16 December 2021

Your Ref: BR/119/21/PL

Re-Submission of s.78 planning application – 73-75 Aldwick Road, Bognor Regis

Note: Rev. B **Plan-No.:** CBL-1020235-P203

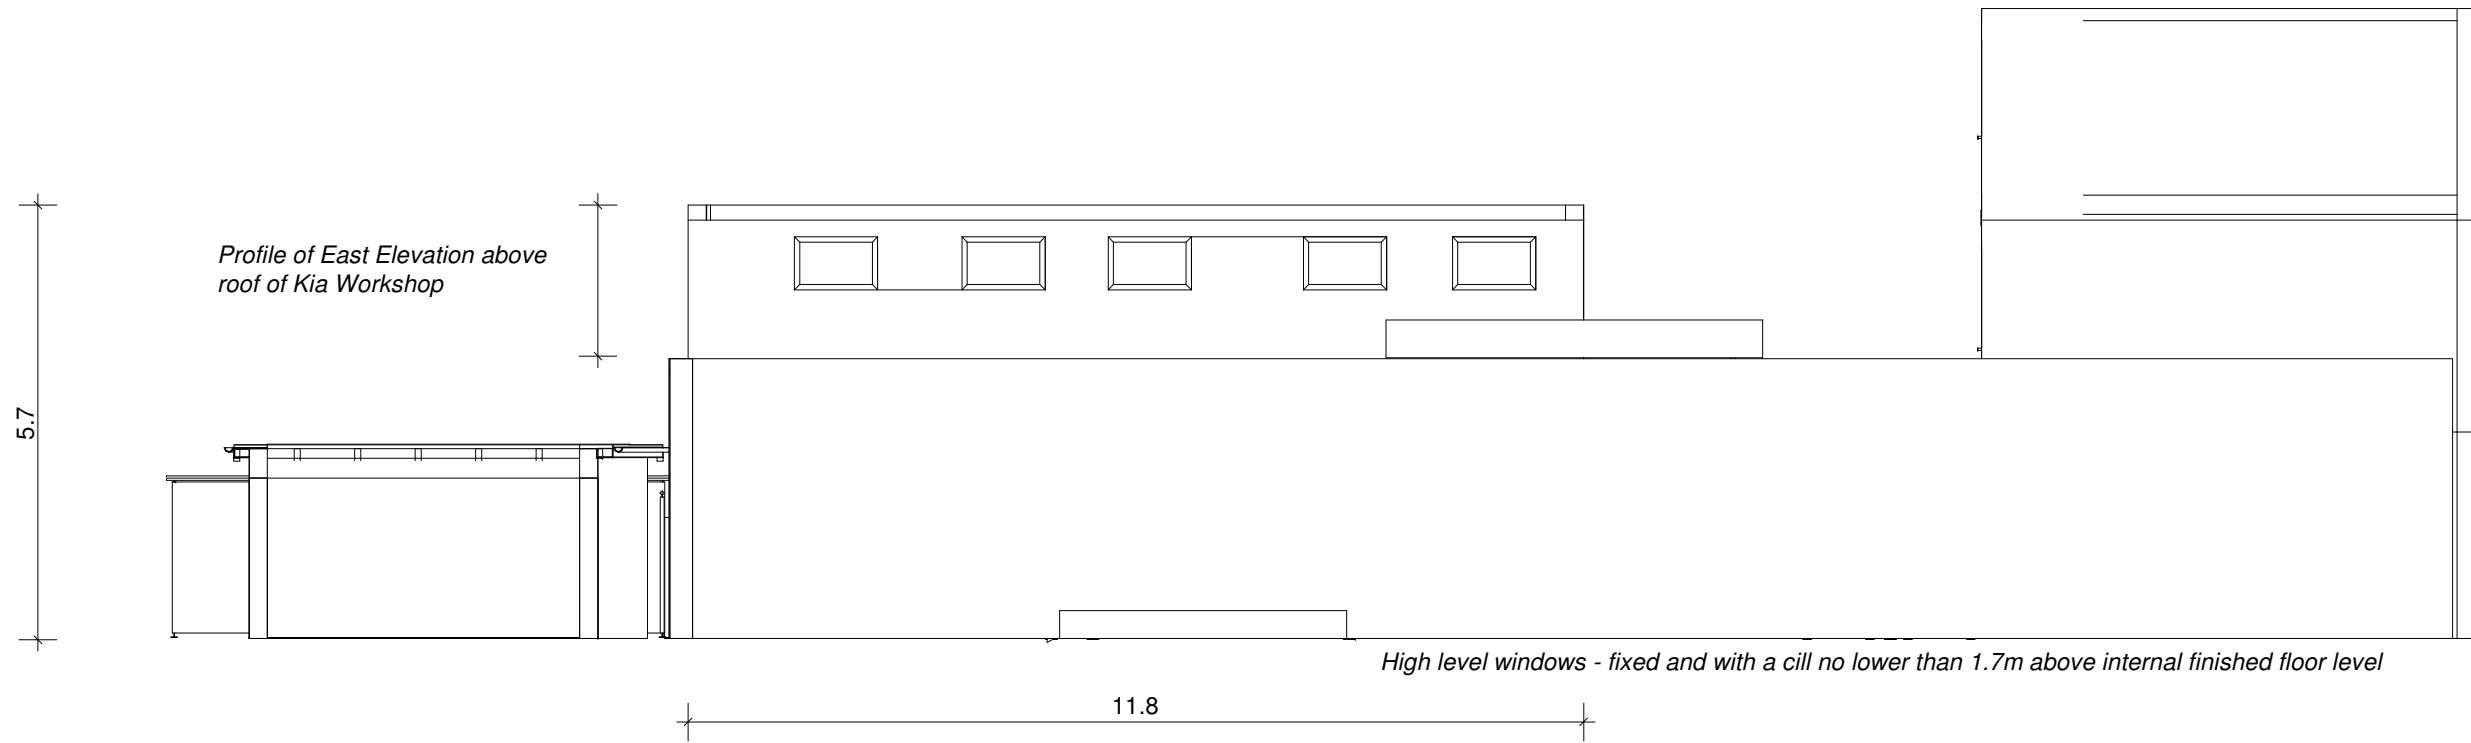
- Greater articulation be given to the front (west) elevation of the building
- The insertion of high level windows in the east facing elevation
- The potential for a green roof if the pitches were to be removed
- The reduction in size of the ground floor room in Unit 2 and so it was no longer a bedroom
- The use of alternative materials within the front elevation
